Our ref: SSD-5544-Mod-7

Subject: Request for Additional Information – Infrastructure consolidation and remediation, Kurnell Refinery Conversion (SSD-5544-Mod-7)

Attachment 1: The Department's comments on the Submissions Report

**FIGURE F3:
FIRE WATER SYSTEM AND
OILY WATER SEWER**

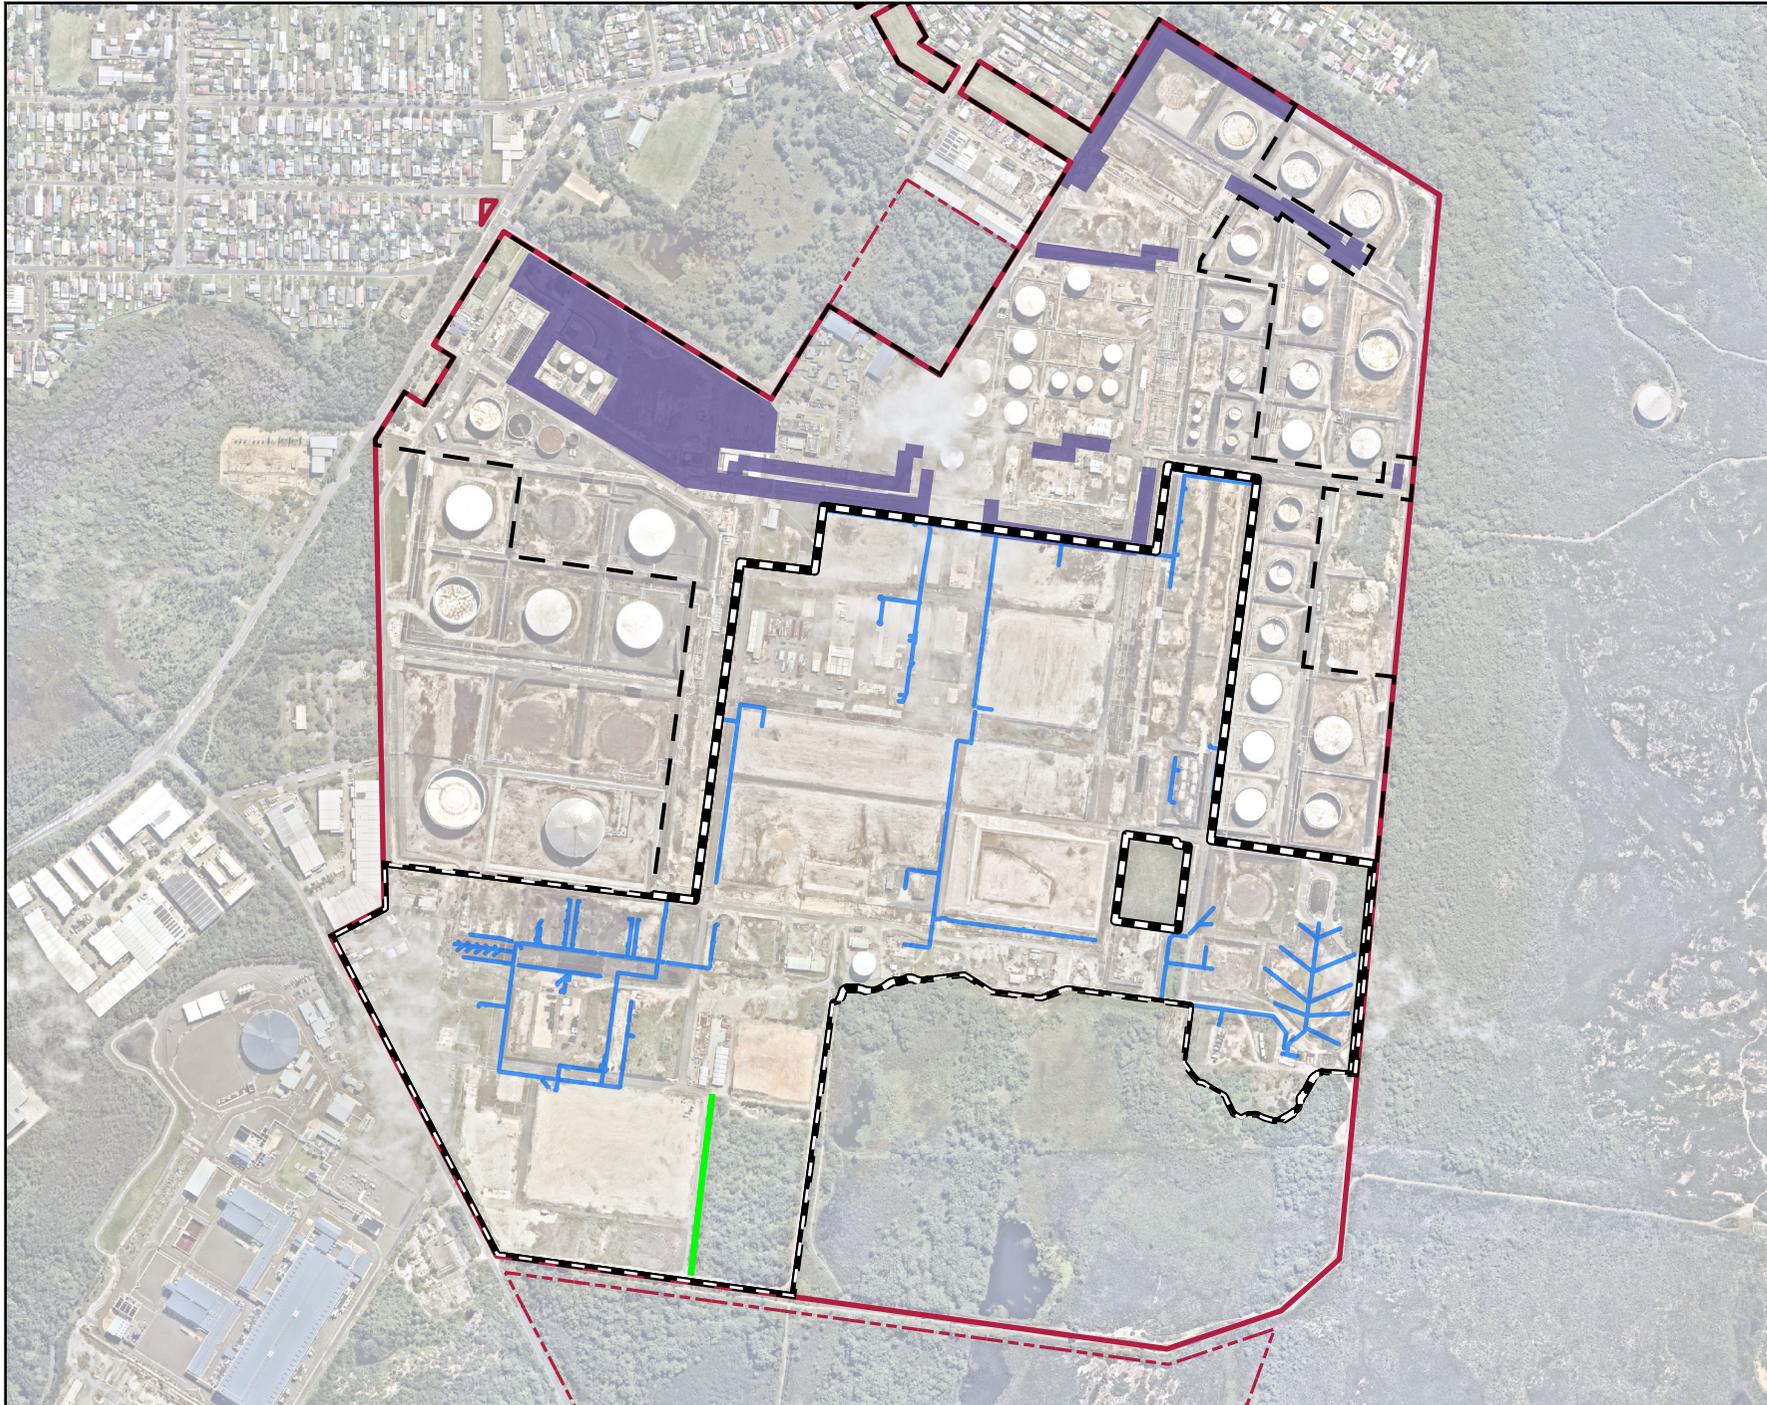
4. It is understood that the new permanent pump station and emergency storage tank in Zone 2 will be installed so the OWS can support the remediation activities. The consolidated project description states that *“following remediation ..., the land within Zones 2 and 3 would no longer need to be serviced by the OWS. At this time, remaining OWS infrastructure would be removed from Zones 2 and 3, except for ACS Containment Cell connections and diversions”*. Please clarify whether this removal of the OWS system following completion of remediation activities in 2030 would include the pump station and emergency storage tank.
